**COMMUNITY SERVICES DEPARTMENT**

February 4, 2020

**Subject: Man Cave at Bentgrass Meadows Drive Minor Subdivision  
(Final Plat)**

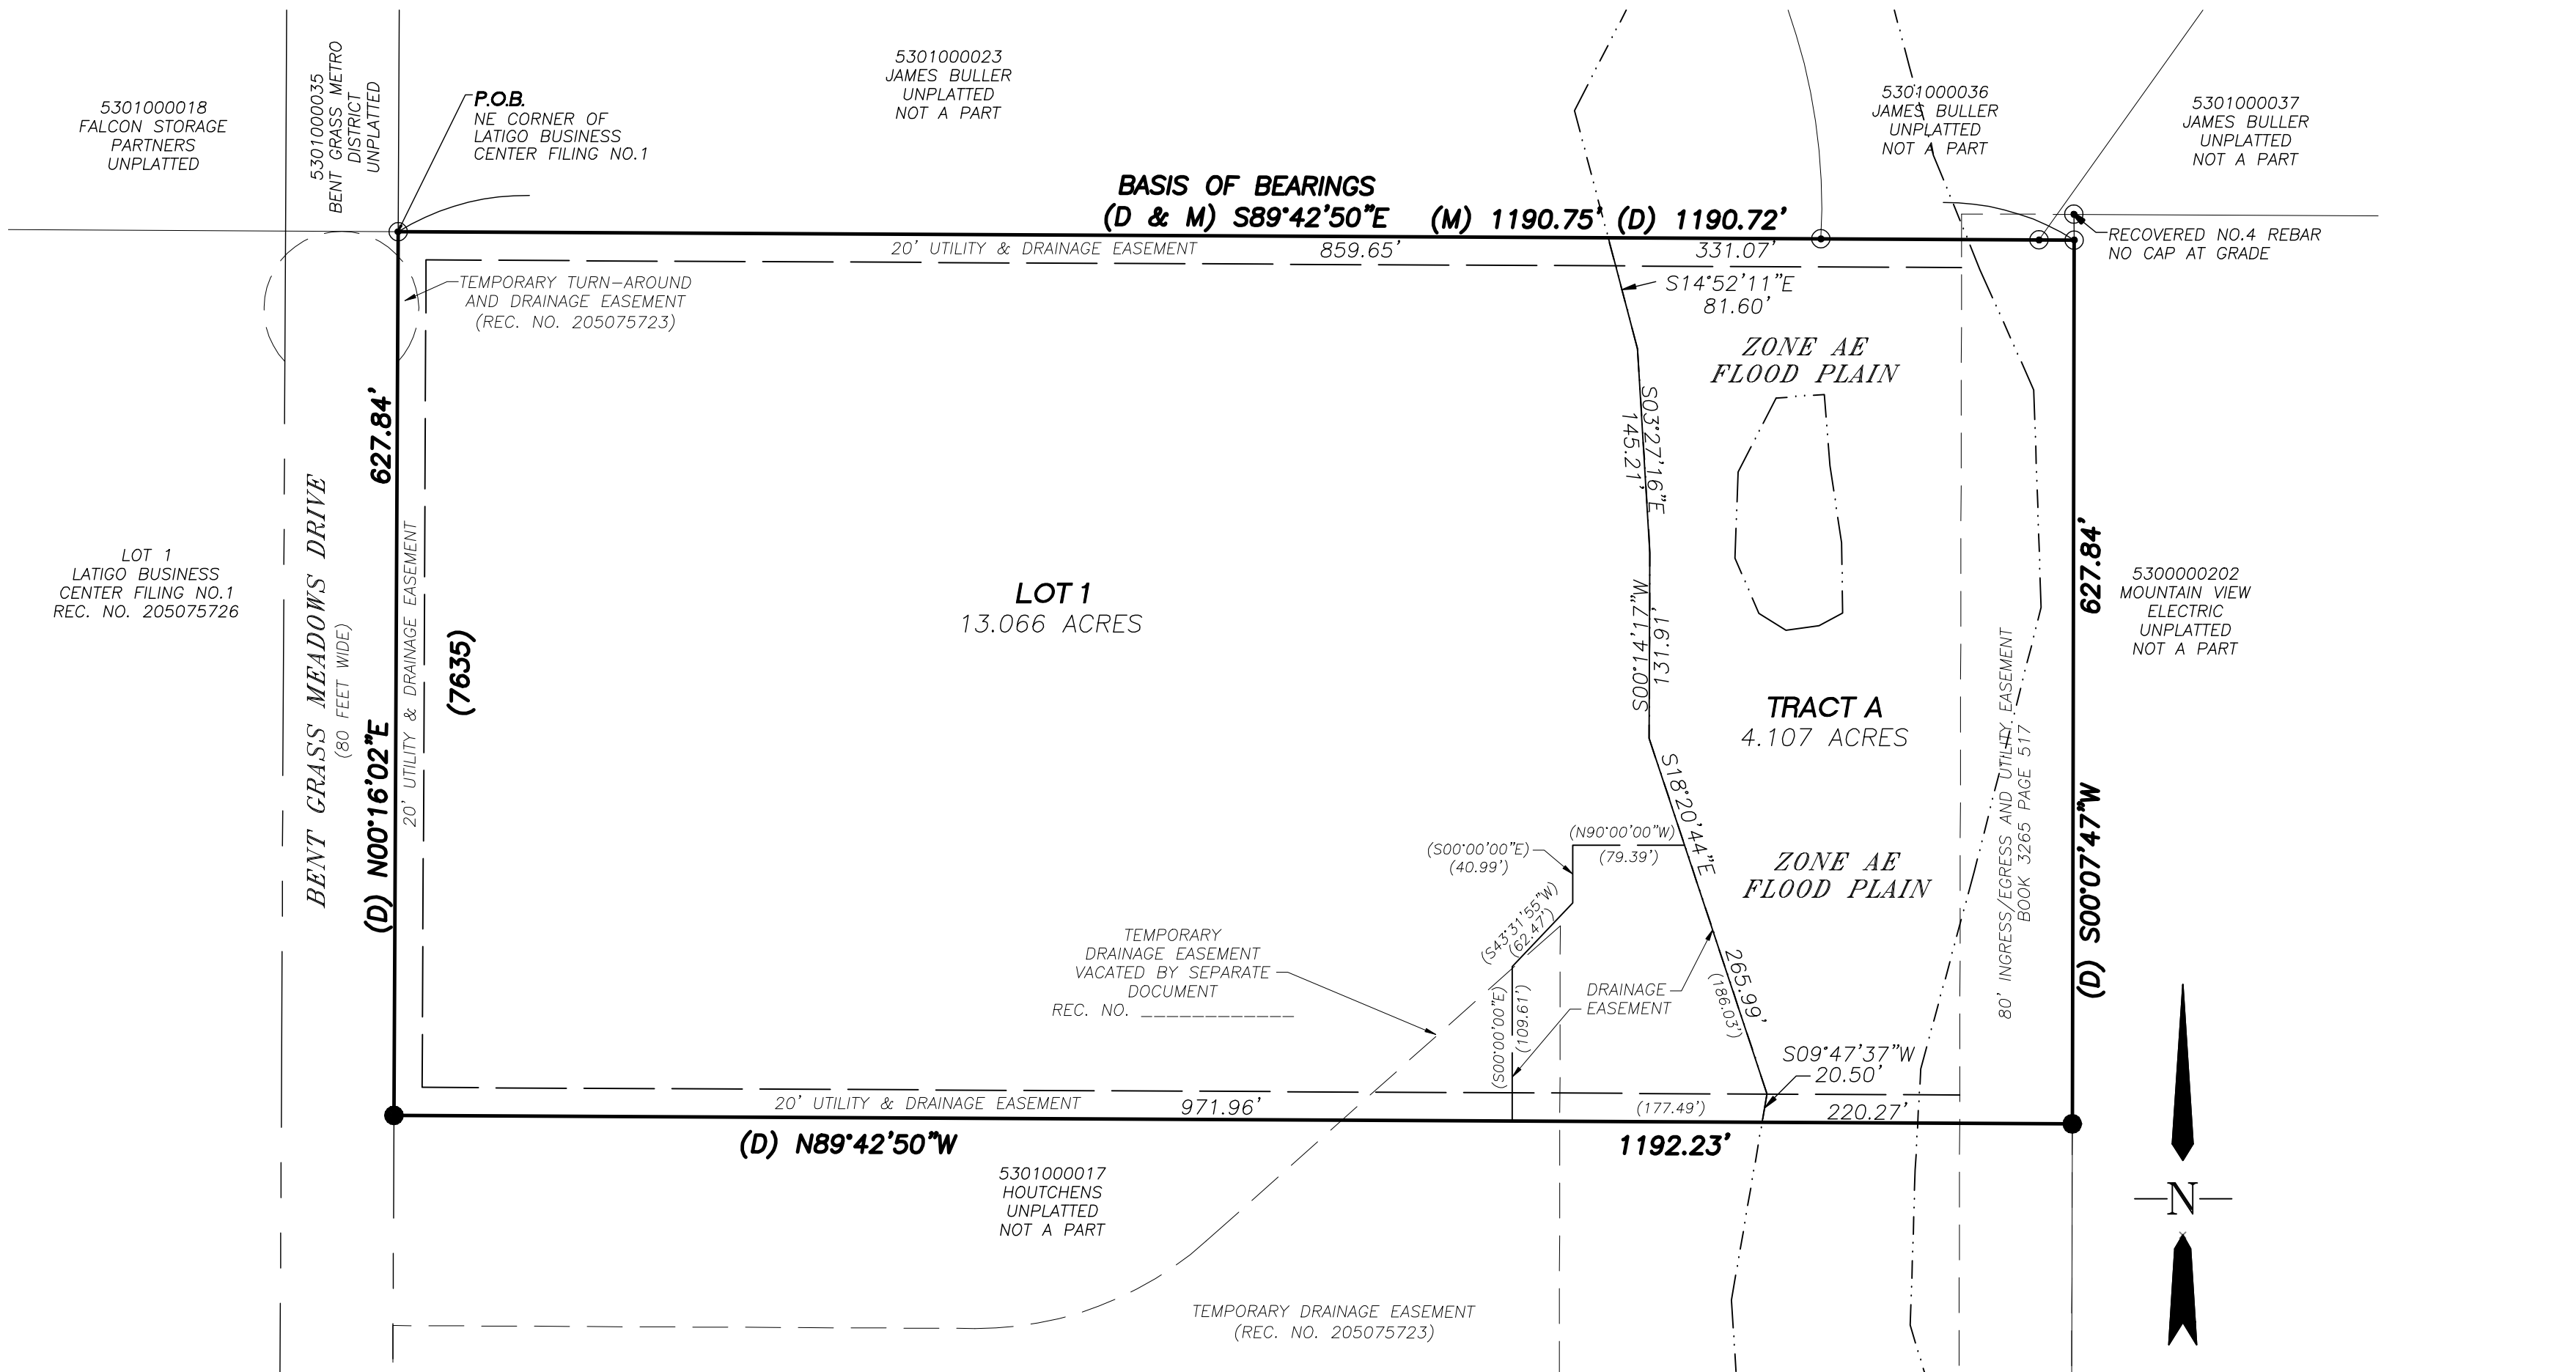
County Parks requests trail easements where development projects impact proposed County trails. As it pertains to this application, the County requests that the landowner provide a 25-foot public trail easement along the east side of the stream that bisects the property, which will allow for public access,

as well as construction and maintenance by El Paso County of the Woodmen Hills Secondary Regional Trail, and this easement shall be shown and dedicated to El Paso County on this Final Plat.

**Staff Recommendation:** Recommend to the Planning Commission and the Board of County Commissioners that the approval of Man Cave at Bentgrass Meadows Drive Minor Subdivision include the following conditions: designate and provide to El Paso County a 25-foot trail easement along the east side of the stream that bisects the property, which will allow for public access, as well as construction and maintenance by El Paso County of the Woodmen Hills Secondary Regional Trail, and this easement shall be shown and dedicated to El Paso County on this Final Plat.
